Application # 150014094R  
1209828 SEACREST

SURVEY FOR: <b>PROPOSED PLOT PLAN - LOT - 59</b> <b>FOREST OAKS S/D, PHASES ONE &amp; TWO</b>		<b>BENNETT SURVEYS, INC.</b> 1662 CLARK RD., LILLINGTON, N.C. 27546 (910) 893-5252	
TOWNSHIP ANDERSON CREEK	COUNTY HARNETT	20 0 40	SURVEYED BY:
STATE: NORTH CAROLINA	DATE: APRIL 17, 2006	SCALE: 1" = 40'	DRAWN BY: RVB
ZONE	WATERSHED DISTRICT	TAX PARCEL ID#:	CHECKED & CLOSURE BY:
			FIELD BOOK
			DRAWING N
			06222

lot 59 forest dnr

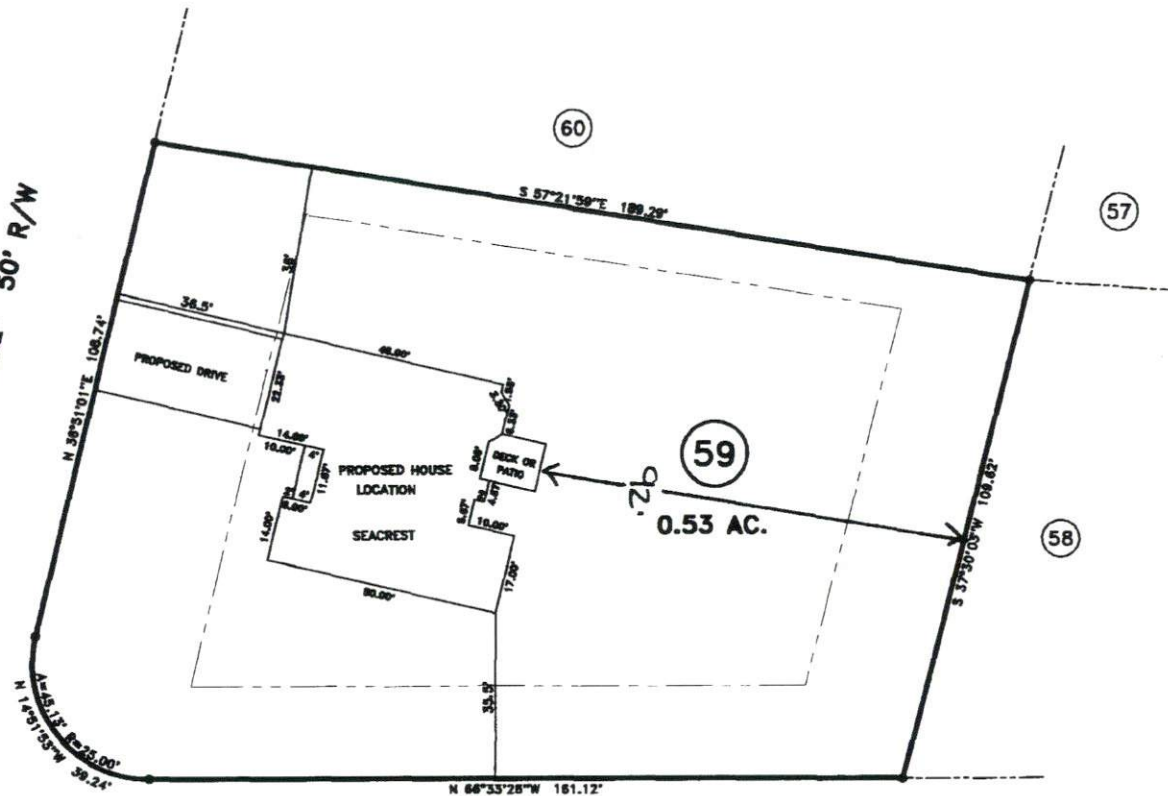
Move house out of area

marked Septic & Repair Area

Drive out either corner

from Holly Oak Creek (not in Septic Area)

or on SALT SOUTH Circle it must be

Along Property Line (12' wide max)

There must be 3 Bedrooms or Less
